TO: All Staff  
FROM: Public Works Plan Review Team  
DATE: January 28, 2022  
SUBJECT: SX-22-00002 Elk Meadows

**Public Works has reviewed the Shoreline Exemption Application. Please see comments below:**

**ELK MEADOWS MAIN SPAN REPAIR**  
**Elk Meadows Home Owners Association**  
McKroy Road Cle Elum, WA 98922  
General Plan

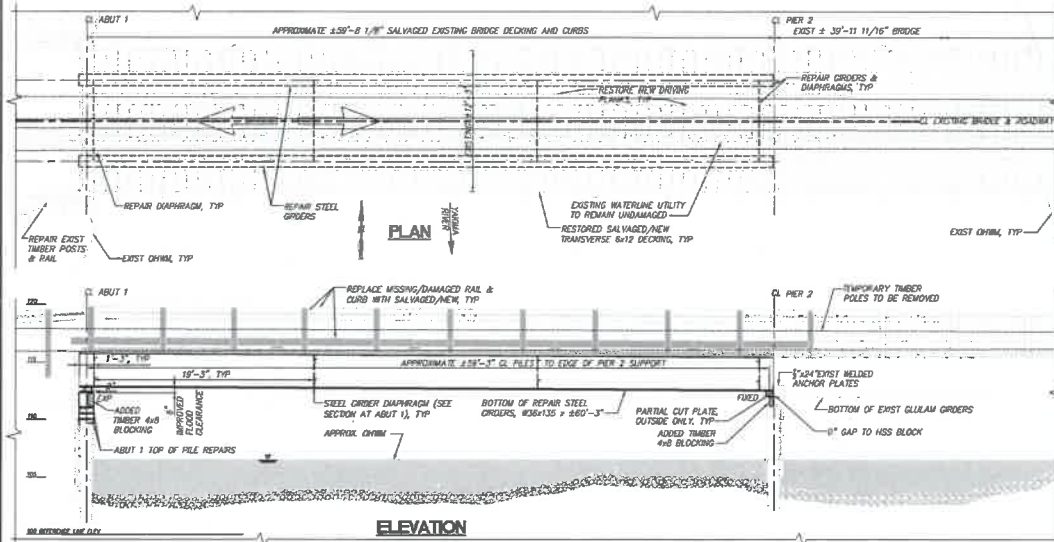
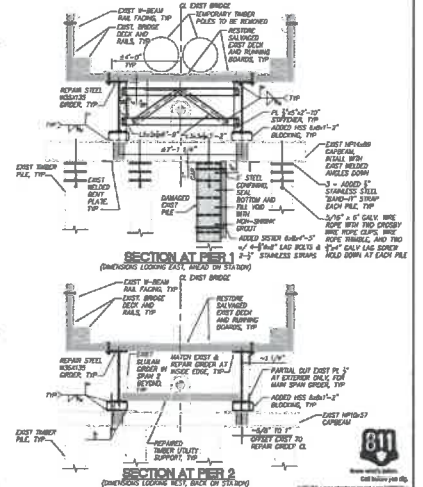
Kittitas County Public Works can issue a floodplain development permit authorizing the temporary use of the proposed bridge without requiring a hydraulic analysis. A hydraulic analysis will be required for a permanent bridge. The Flood Control Zone District has secured funding and can provide technical assistance to the applicant and conduct this required analysis. The results of this analysis will help inform bridge requirements to verify that use does not significantly or cumulatively increase flood hazards (KCC 17B.05.030), that the bridge does not constrict the river or impede the flow of the “ordinary high water, sediment, and woody debris” (KCC 17B.06.180(B)(5)) and that floodway requirements are met (KCC 14.08.300).

A private bridge application has been submitted and is being reviewed for conformance to KCC 12.01.110, 12.01.120 and 20.02.050. Based on the immediate need to provide access this structure is being installed a temporary structure with subsequent hydraulic analysis. Should bridge revisions be required to address bridge structure, shoreline, or flood damage prevention requirements a new permit submittal may be required at that time.
